**Application no: 23/00207/DISC**

**Location:** Proposed Himley Village North West Bicester, Middleton Stoney Road, Bicester

## **Lead Local Flood Authority**

Objection to discharge condition.

TITLE MIDDLETON STONEY ROAD, MAIN SPINE ROAD JUNCTION. PROPOSED DRAINAGE SHEET 1	
HYDROCK PROJECT NO. C-27141-C	SCALE @ A2 1 : 500
STATUS DESCRIPTION INFORMATION	STATUS S2
DRAWING NO. (PROJECT CODE-ORIGINATOR-ZONE-LEVEL-TYPE-ROLE-NUMBER) 27141-HYD-XX-XX-DR-C-0001	REVISION P01

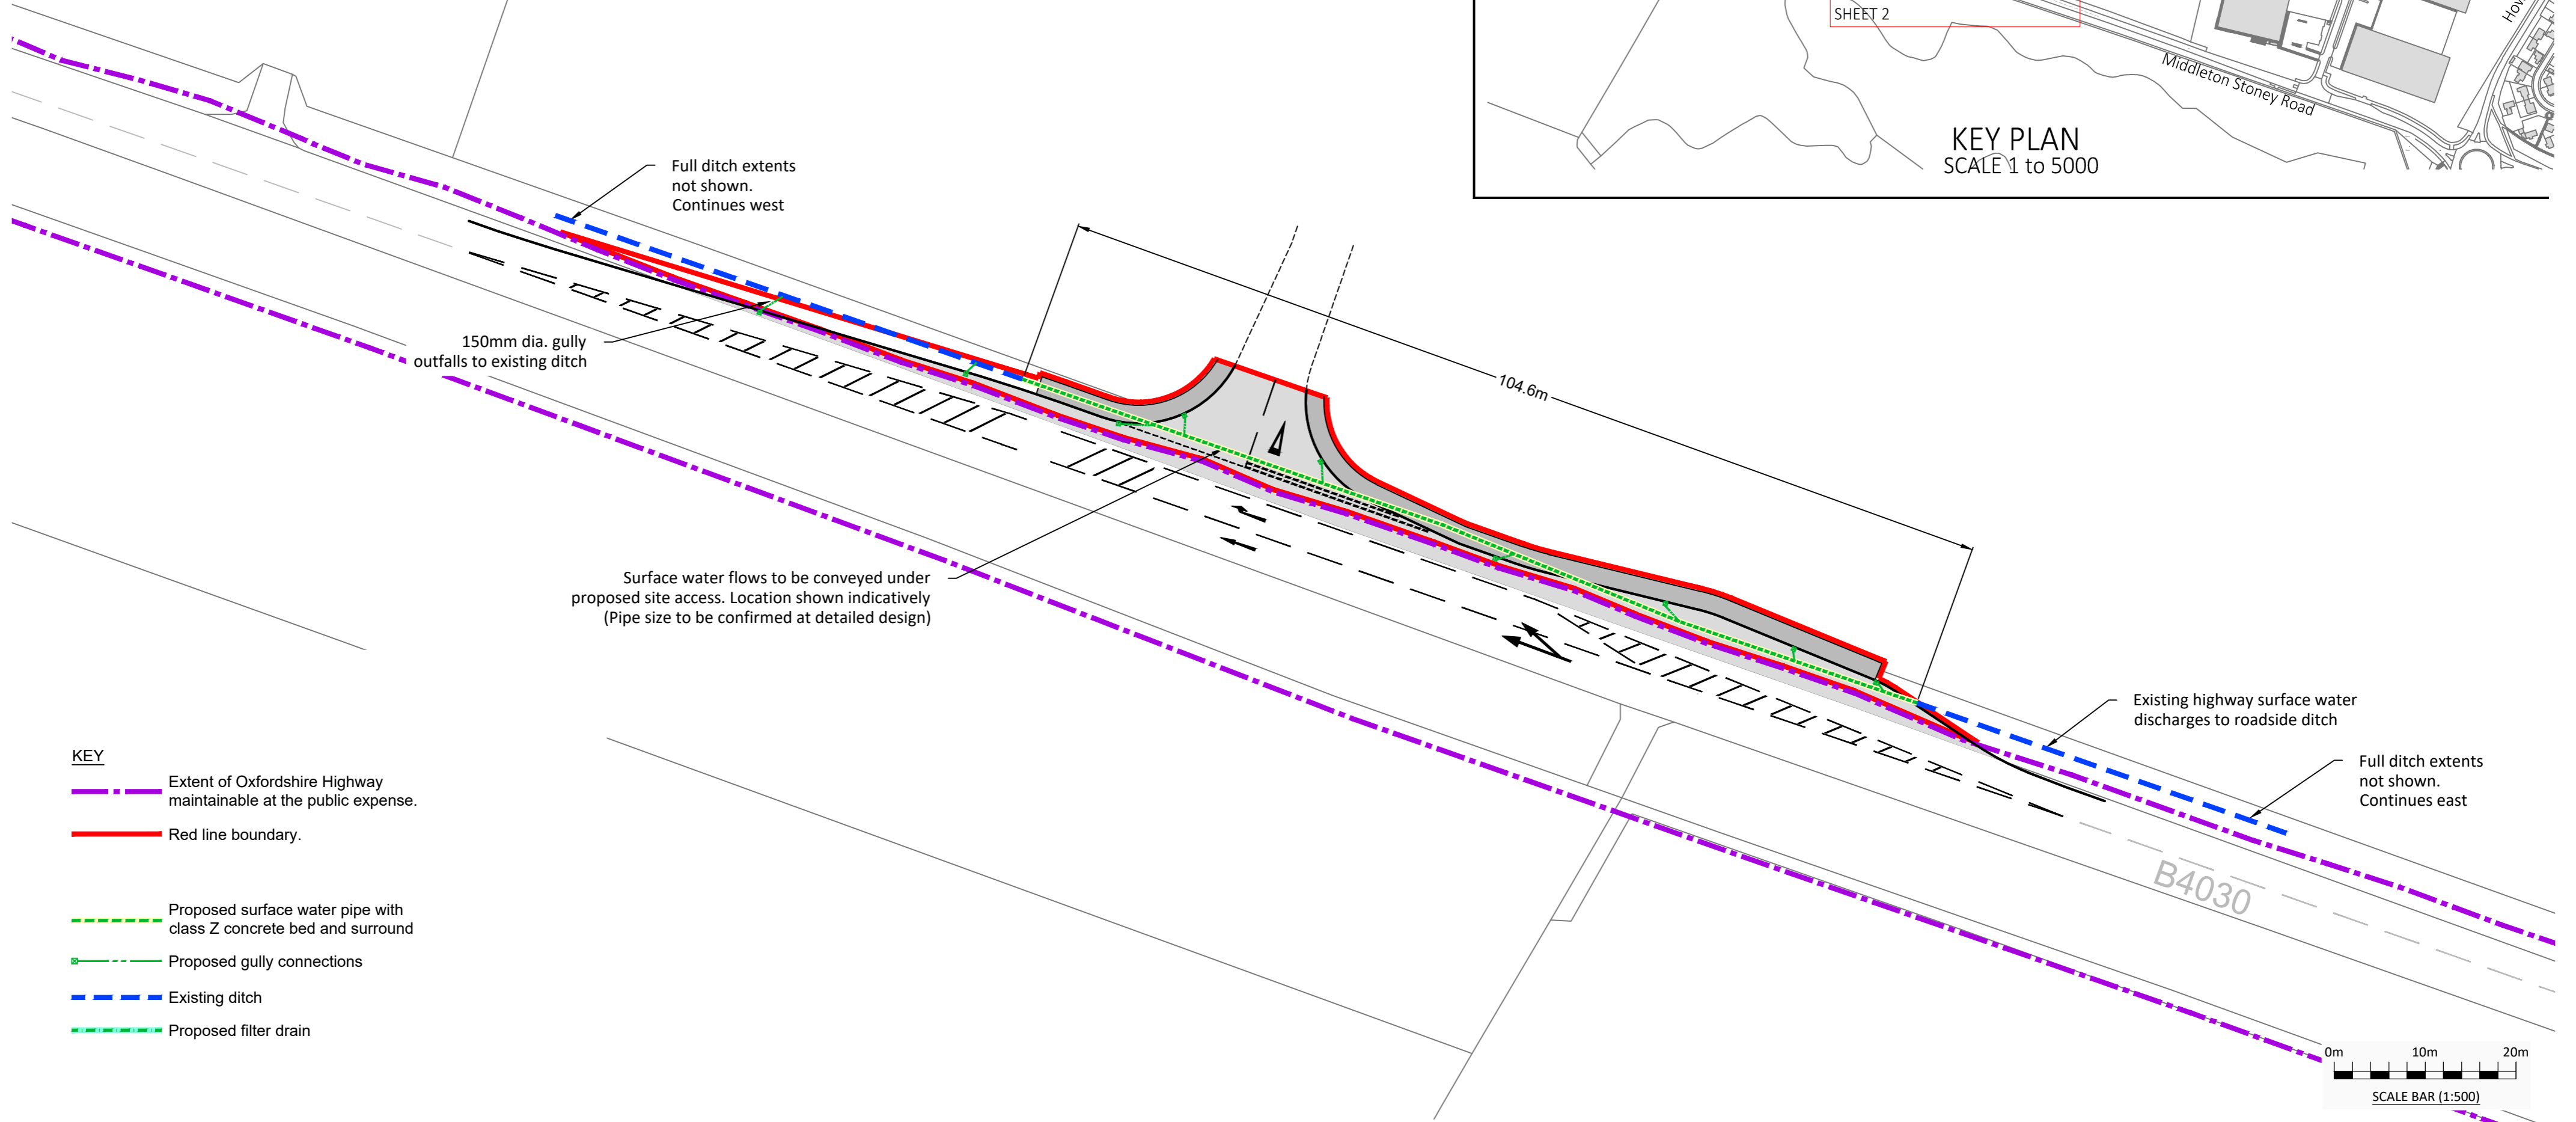
Discharge rates not provided on a drainage plan for each outfall location. Drainage plan not provided.

Drainage plan is required and sizing of SuDS features needs to be shown clearly. Invert and cover levels of all drainage to be showing.

Detailed drainage plan with pipe numbering not provided.

Detailed drainage plan not provided to illustrate the SuDS features.
